SSD-29508870 for Birriwa Solar Farm at Barneys Reef Road and Birriwa Bus Route South, Birriwa. (various land parcels)

9 November 2022

TfNSW has reviewed the information provided, including a Traffic Impact Assessment (TIA) (dated July 2022) and the Environmental Impact Assessment (EIS) (dated September 2022), both prepared by EMM Consulting P/L, and is not satisfied that the proposed development has adequately addressed the anticipated construction traffic impacts. Accordingly, TfNSW does not support the application as proposed.

BARNEYS REEF ROAD UPGRADE

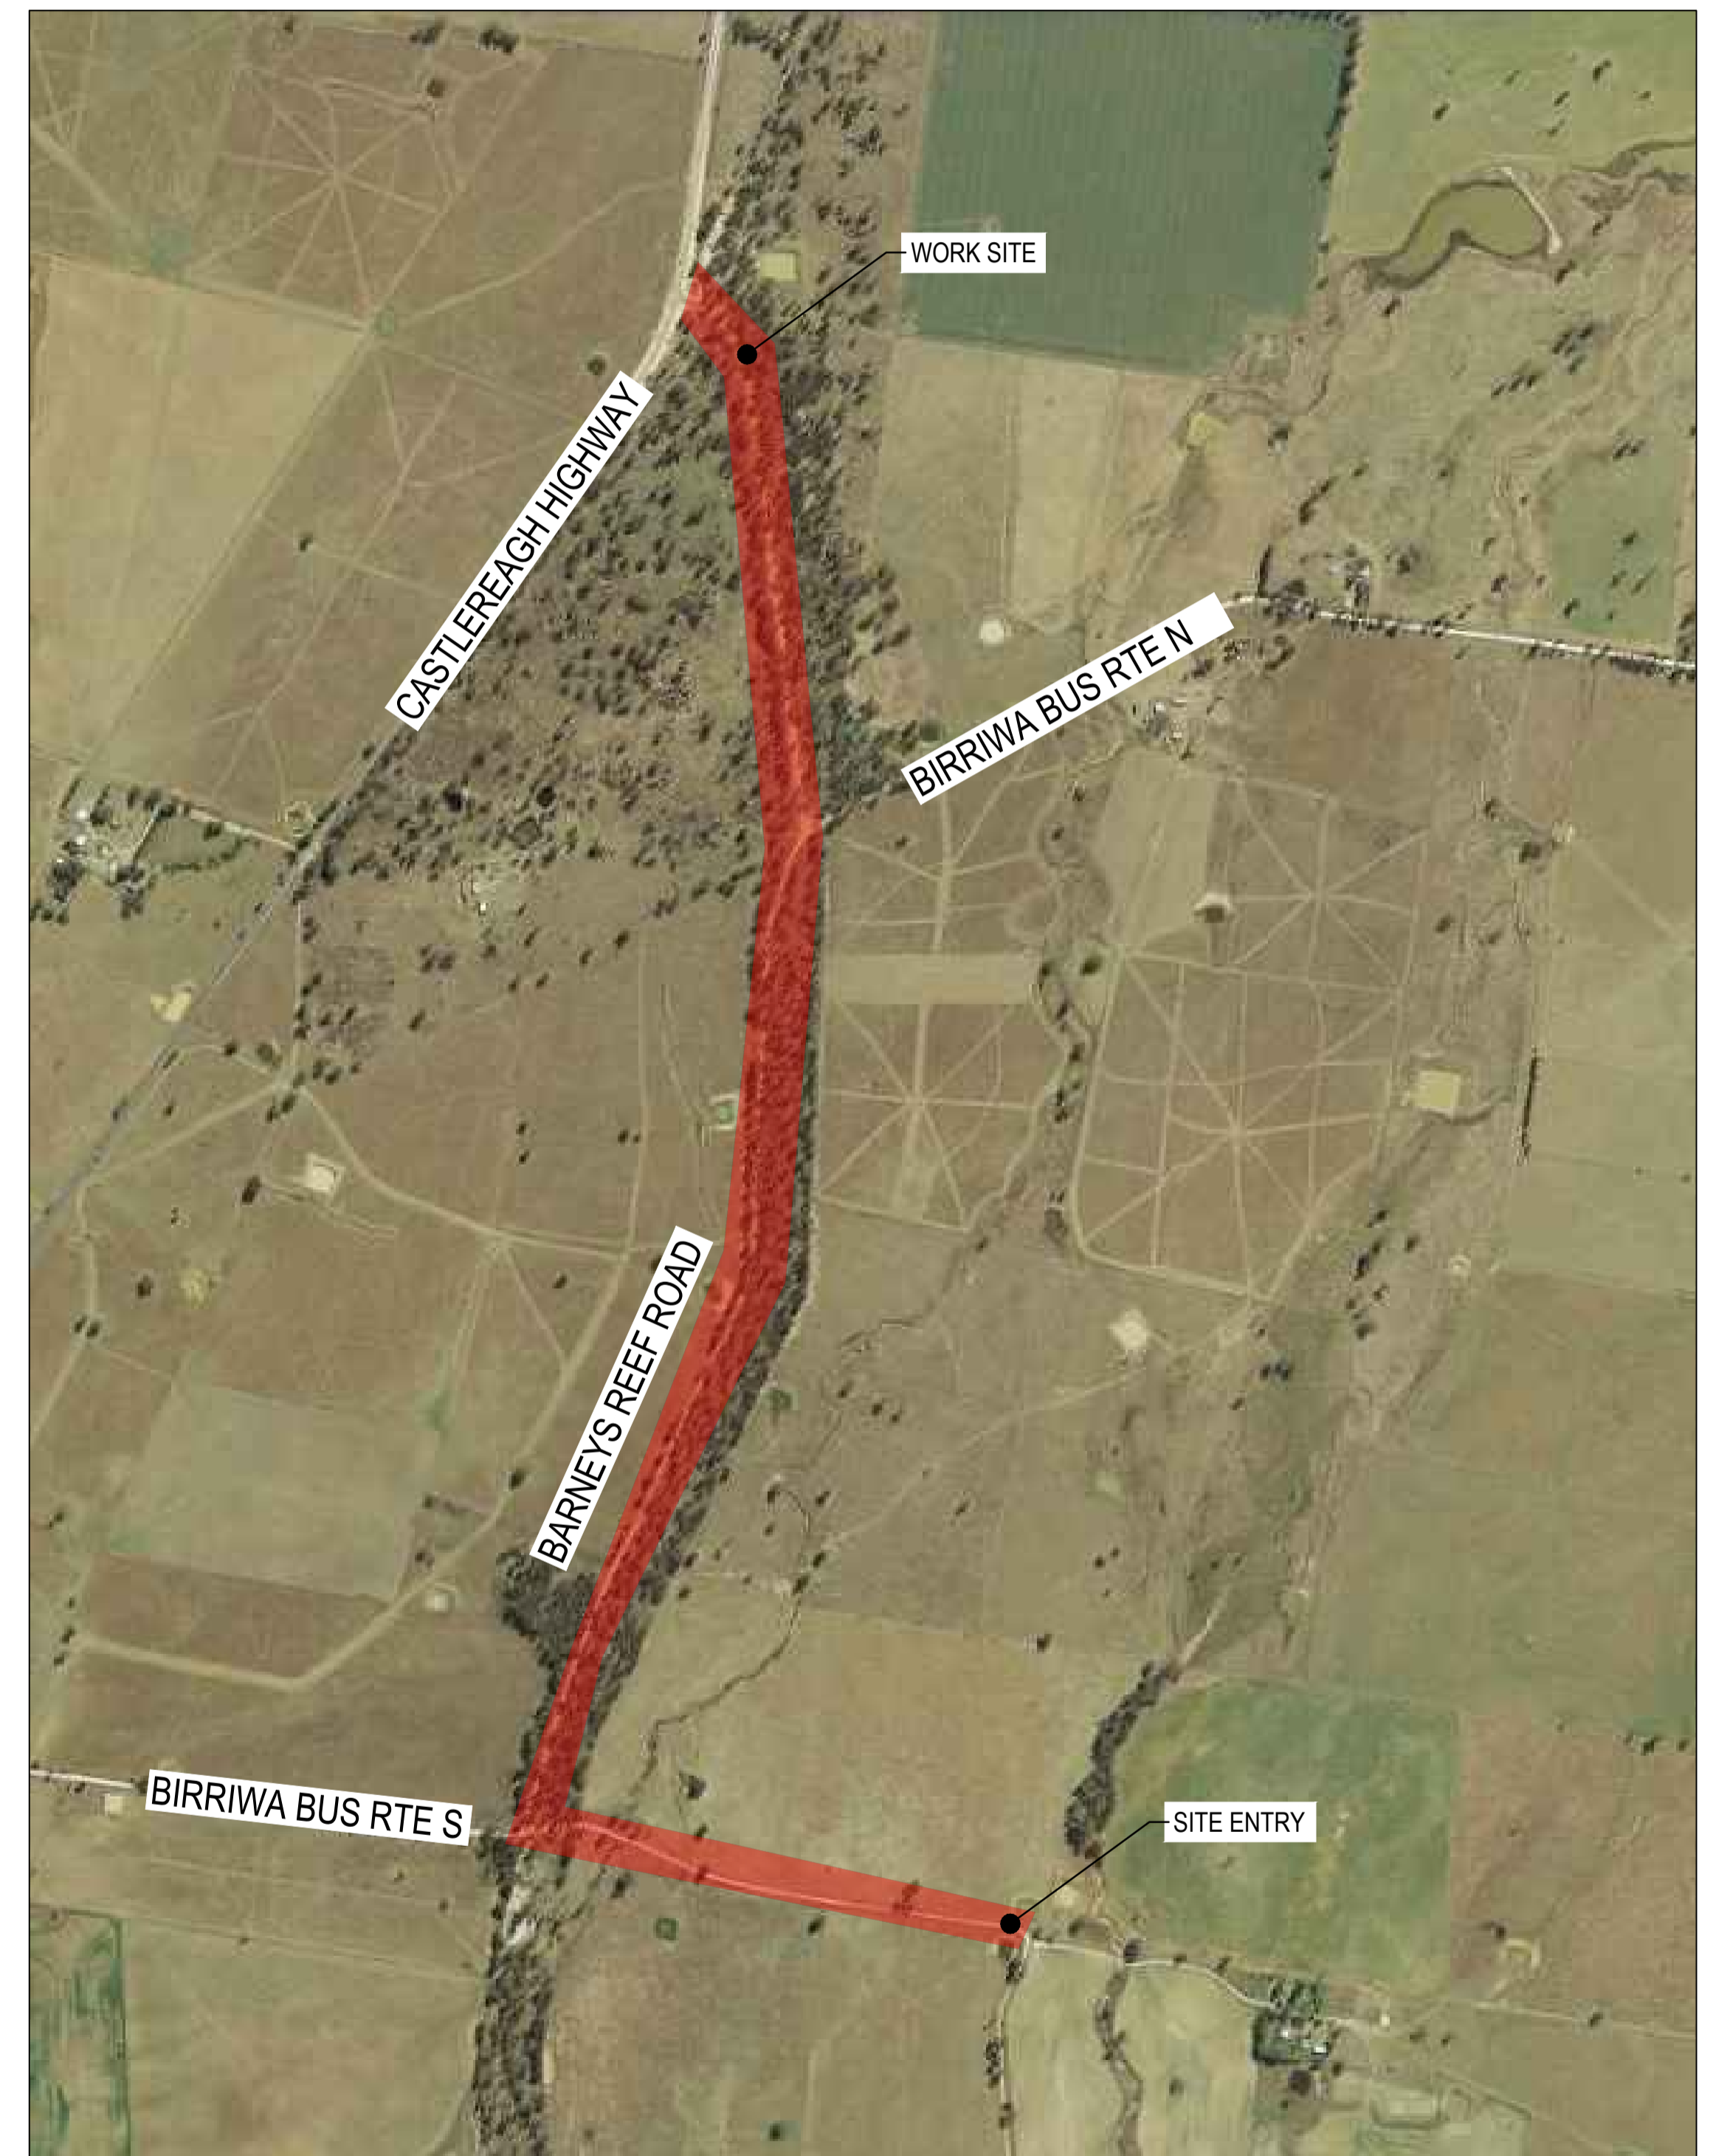
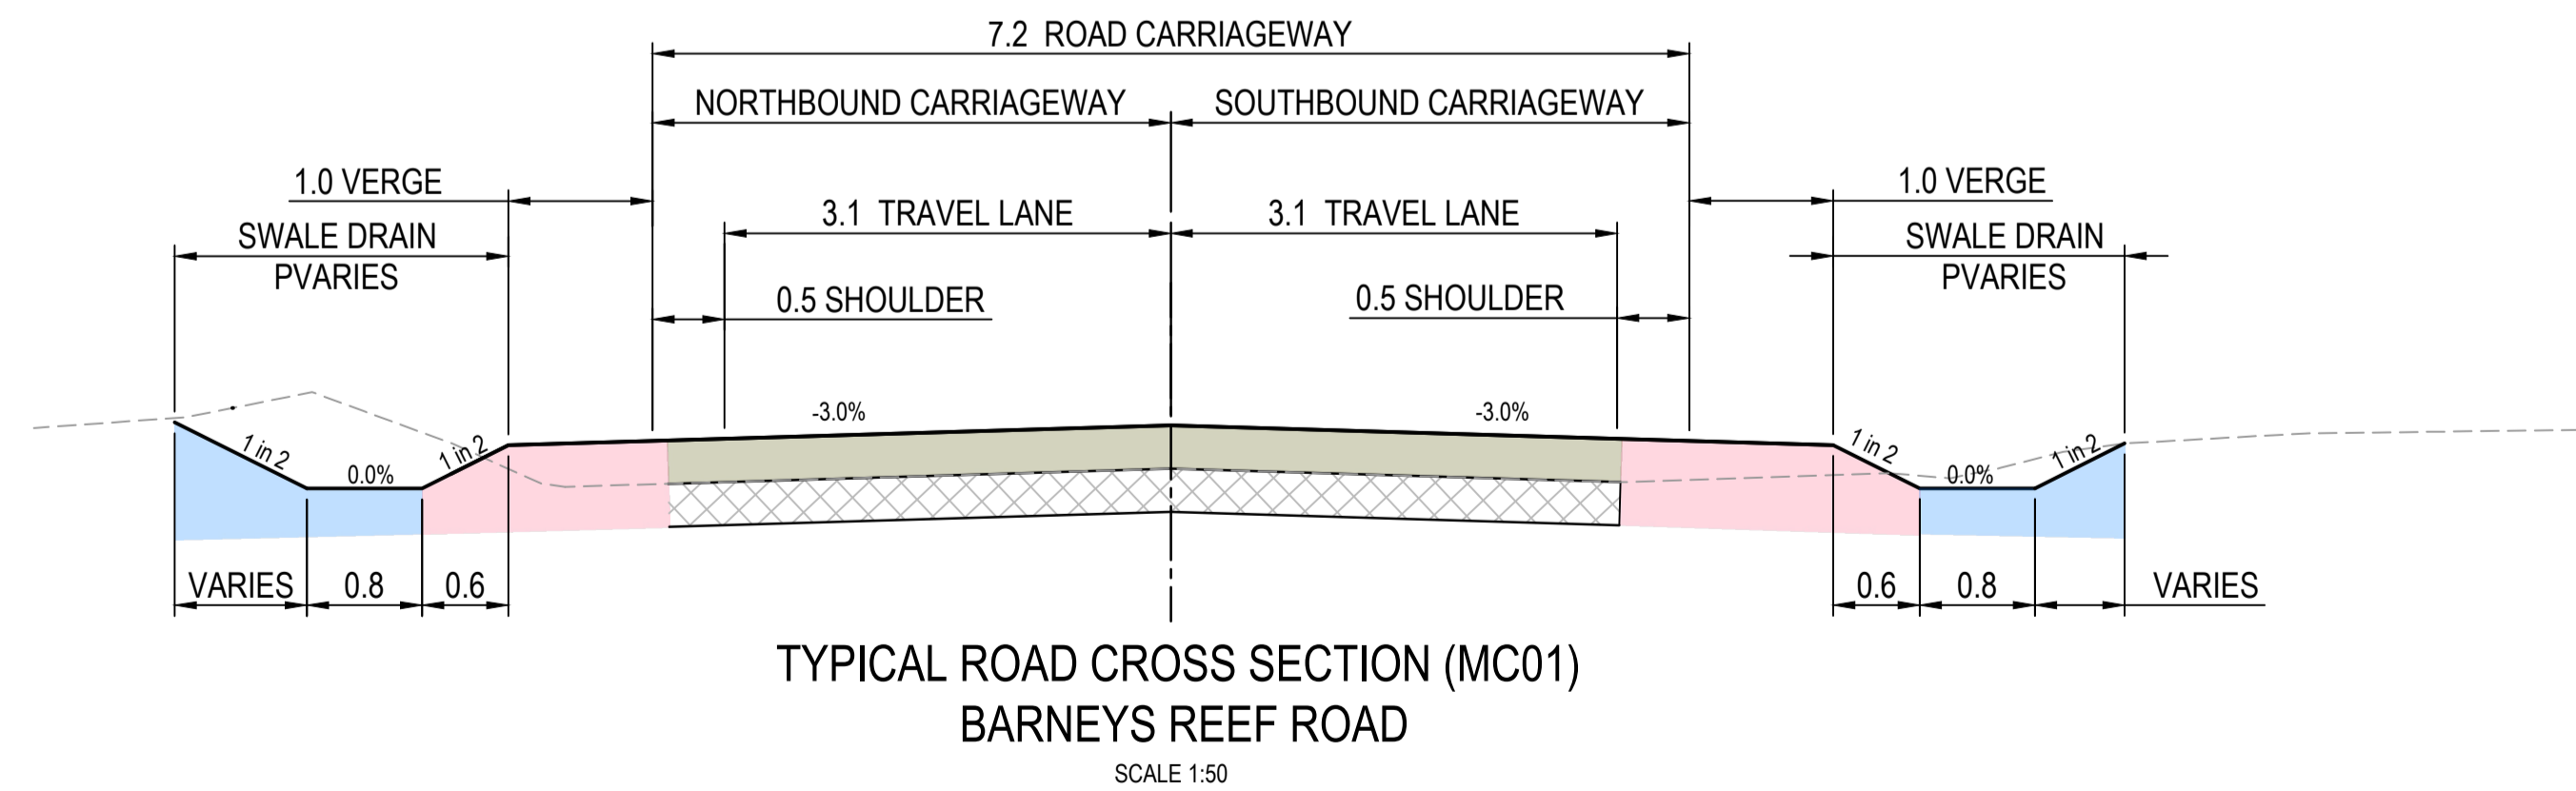
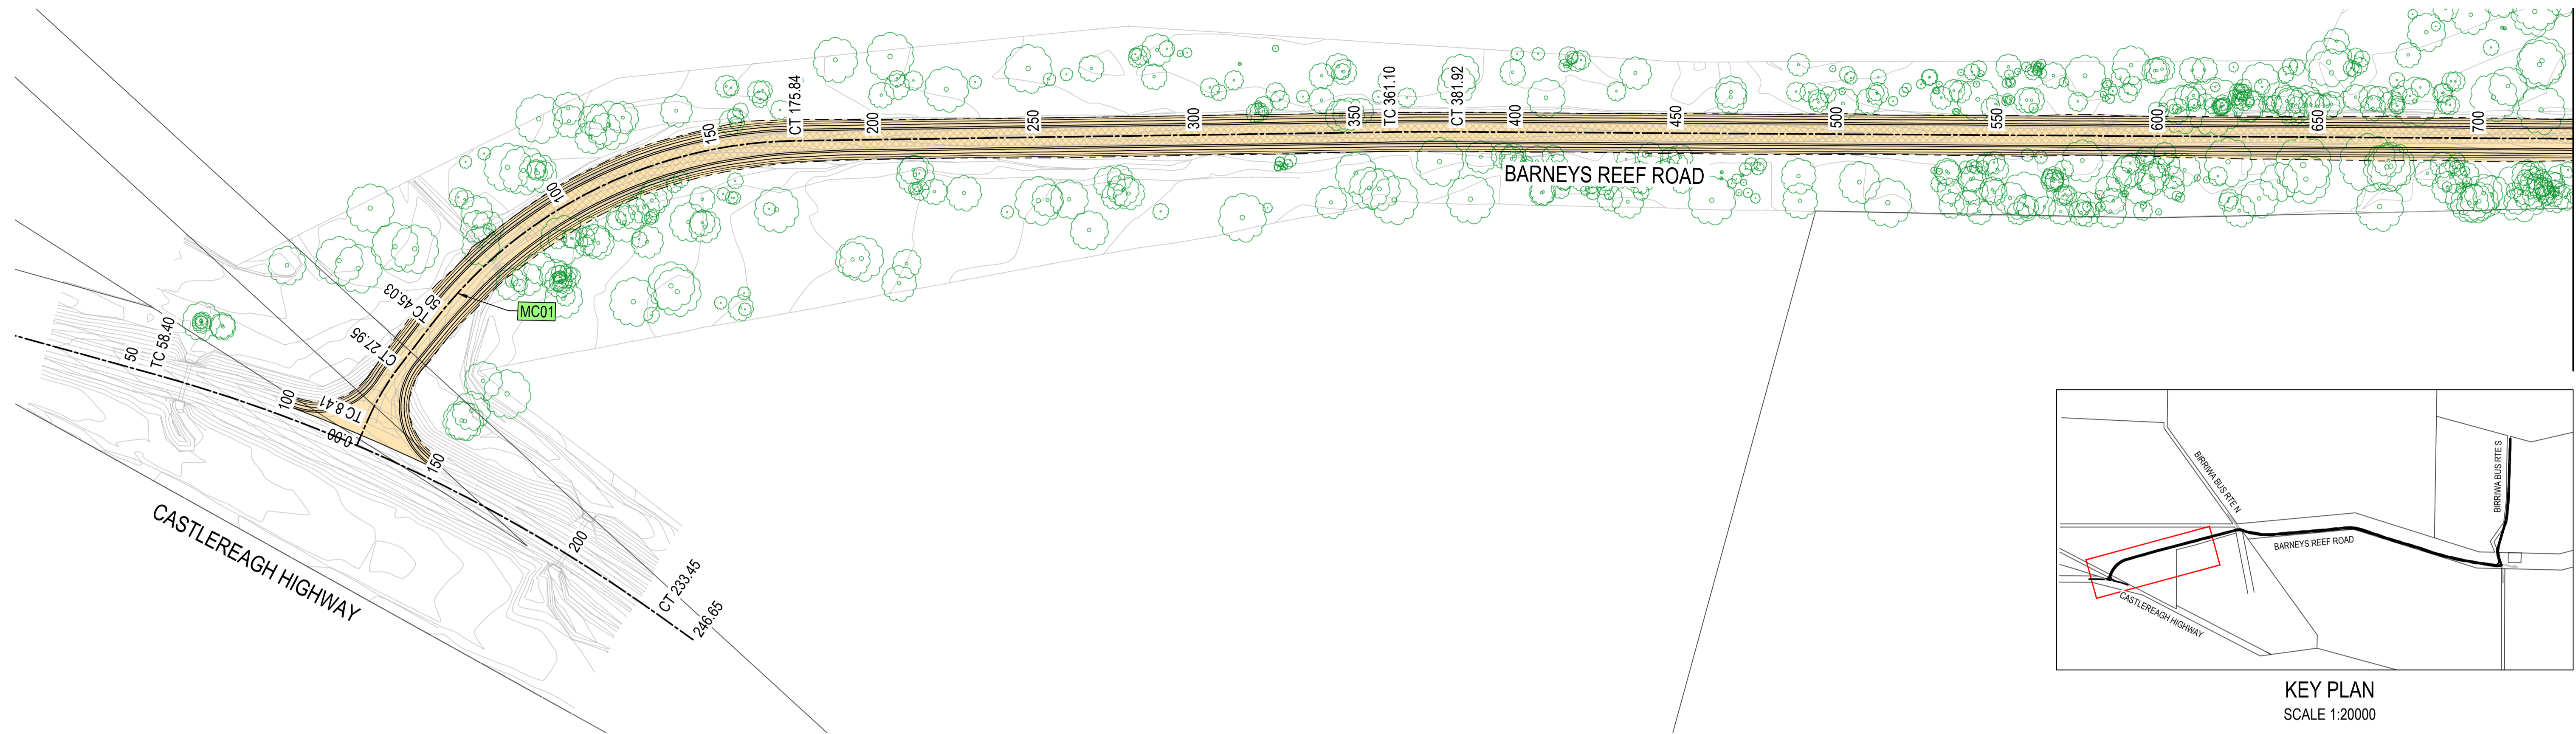
Appendix C to the EIS provides a *Concept Design of the Barneys Reef Road Upgrade*, however this document does not include the abovementioned proposed upgrade works at the key intersection of Castlereagh Highway and Barneys Reef Road. TfNSW require additional information regarding the proposed intersection upgrade works, to ensure that any impacts of the works on the classified road network and associated environmental approvals are identified & addressed prior to determination.

It is recommended that the Consent Authority request the applicant to provide a scaled strategic design of the proposed access addressing the below points for consideration, showing:

- Plans, cross sections & long sections, demonstrating the full scope of works required for any upgrade to the Castlereagh Highway and Barneys Reef Road intersection. Including but not limited to provision of:

- The intersection upgrade included the identified CHR and AUL turn treatments, designed and constructed in accordance with the relevant *Austrroads Guidelines*, *Australian Standards* and related *TfNSW Supplements*, with 3.5m lane widths, 1m wide centre line, 2m sealed shoulders (addition to turning lanes), 1m verge & 6:1 or flatter batters.

- Extent of the existing and / or proposed sealed road surface along Barneys Reef Road from the intersection connection.
 - removal of trees, relocation of utilities, stormwater management, etc.

- Safe Intersection Sight Distance (SISD) requirements in accordance *Austrroads Guide to Road Design Part 4A* with for a design speed of 110km/h are achieved in both directions at the intersection with Castlereagh Highway.

- Swept path diagrams, demonstrating that all required design vehicles (including Over Sized Over Mass (OSOM)) will be able to safely and efficiently arrive and depart the key intersection in both directions to access the site, travelling wholly within the required travel lanes and no additional works will be required to accommodate those vehicles.
